Rezoning Transportation Analysis

Petition Number: 2021-119

Date	Description
09-23-2021	First Review (KP)
11-22-2021	Second Review (KP)
12-20-2021	Third Review (KP)
03-21-2022	Fourth Review (KP)

SHEET NUMBER  
**RZ-1**

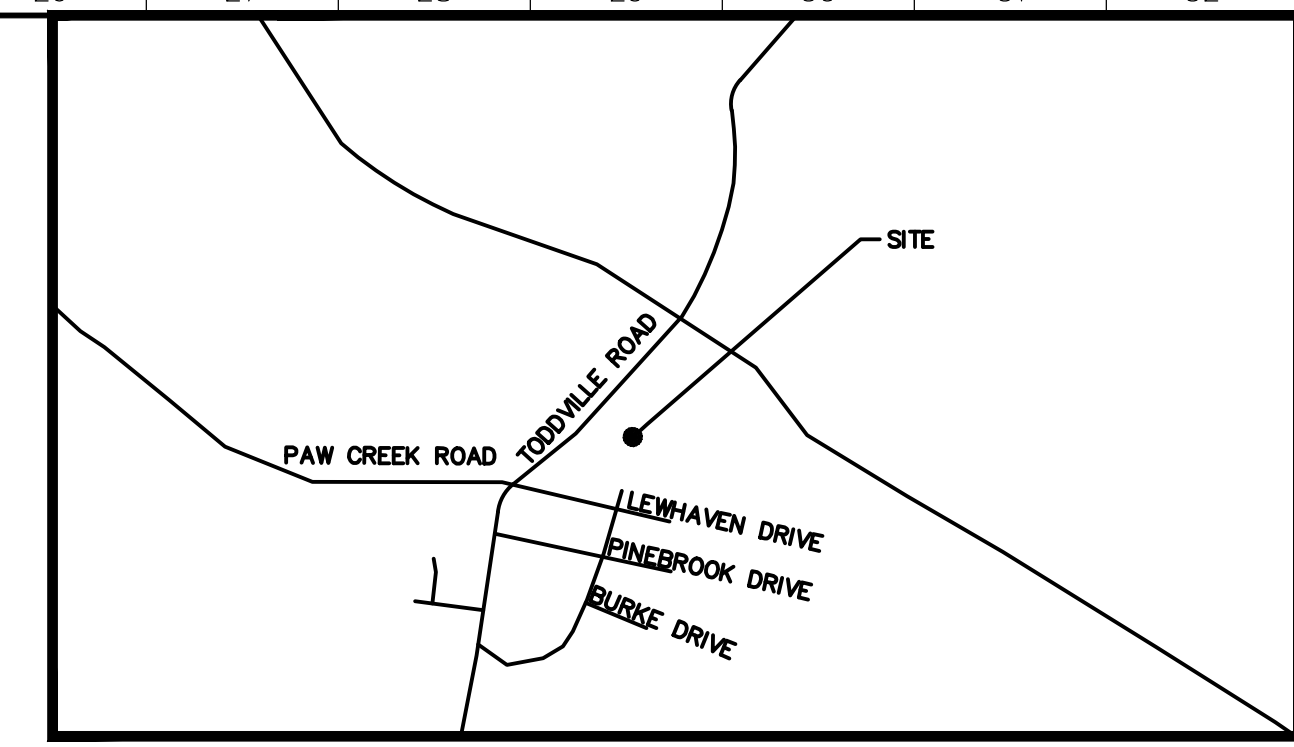
Update to Comment as a Result of the 11-15-2021 Site Plan: Revise Site Plan Note 2 to: "Developer will coordinate with NCDOT, during permitting, to construct a left turn lane on northbound Freedom Drive to turn onto Woodford Lane. The left turn lane will be subject to NCDOT standards and approval!"

- ~~10. **New Comment as a result of the 11-15-2021 Site Plan:** Revise the site plan and conditional notes to commit to provide right in right out ingress and egress at the intersections of Private Alley D and Public Street A and Private Alley A and the approved public street associated with the Freedom Flats Multifamily Development (LDGP-2020-00201). A porkchop island shall be utilized on Private Alley D~~

and Private Alley A, with appropriate ADA pedestrian accommodations, to direct the right in right out movements.

11. **New Comment as a result of the 11-15-2021 Site Plan:** Revise the site plan by modifying the U-02 cross section, shown on sheet RZ-1, to incorporate 6-foot sidewalks as labeled and dimensioned on the site plan.
